October 25, 2016

NOTICE OF VIOLATION AND ORDER TO CORRECT

Re: 39 Deering Street – 047-B-020 – the “Property” - R-6 Residential Zone – Illegal Use of Building

**2** 1st FLOOR PLAN EXISTING  
SCALE: 1/8" = 1'-0"

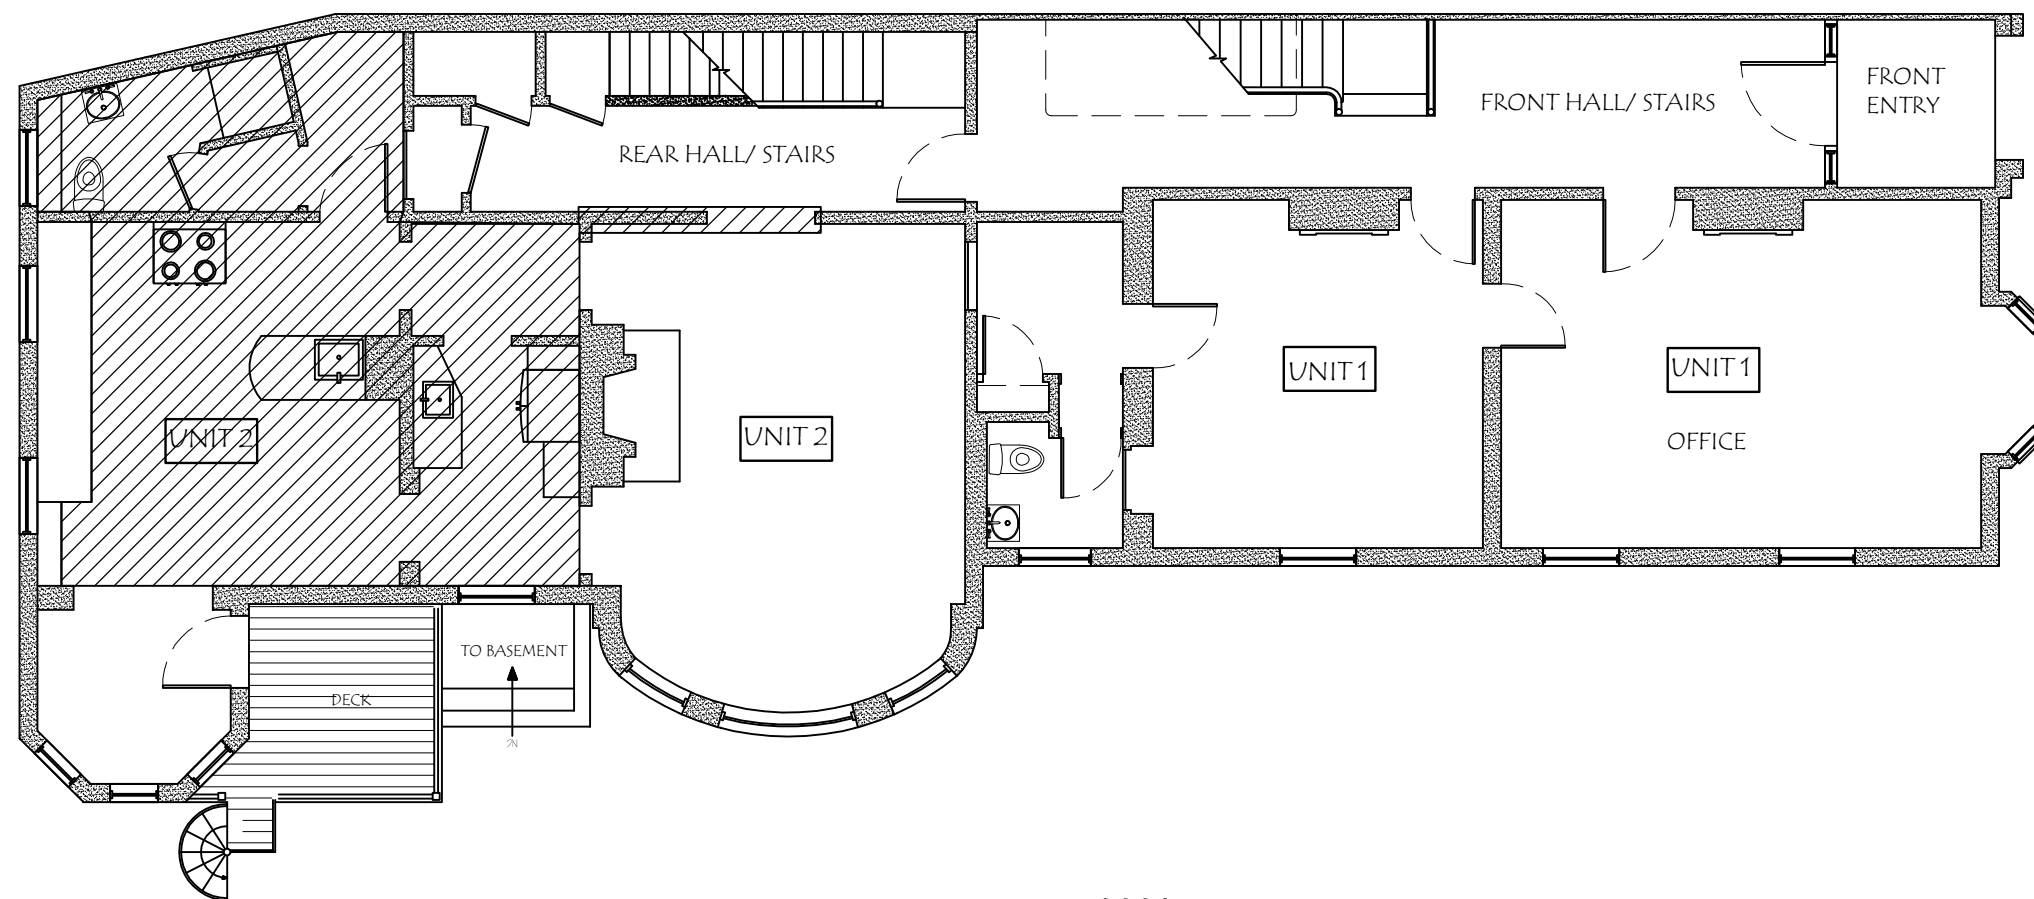
The plans attached to building permit application, #2016-02129, show that Unit #1 at the above referenced property is an illegal office. According to the most recent building permit on file, permit #960816, the current approved use of the Property is a four family dwelling with a home occupation in the main unit. A home occupation is an accessory use within a dwelling unit, and cannot be a stand-alone use in a separate unit. Our records do not show any approved change of use permit or certificate of occupancy to allow Unit #1 to be used as an office separate from a home occupation, and is therefore, not allowed pursuant to the City of Portland Code of Ordinances Sec. 14-463.

1. To keep Unit #1 as a separate office, please obtain a conditional use permit from the Zoning Board of Appeals to change the use to a professional office. You must meet the requirements of Sections 14-137(c)(2) and 14-474 of the Code.
2. To convert Unit #1 into a separate dwelling unit, please obtain a Change of Use permit to change the front part of the first floor into a separate dwelling unit for a total of five dwelling units. You must meet all of the zoning criteria listed in sections 14-139 and 14-140.
3. To combine Unit #1 with the residential unit on the first floor into one residential dwelling unit, as previously approved, please submit revised floor plans for the current building permit application showing it as one unit.
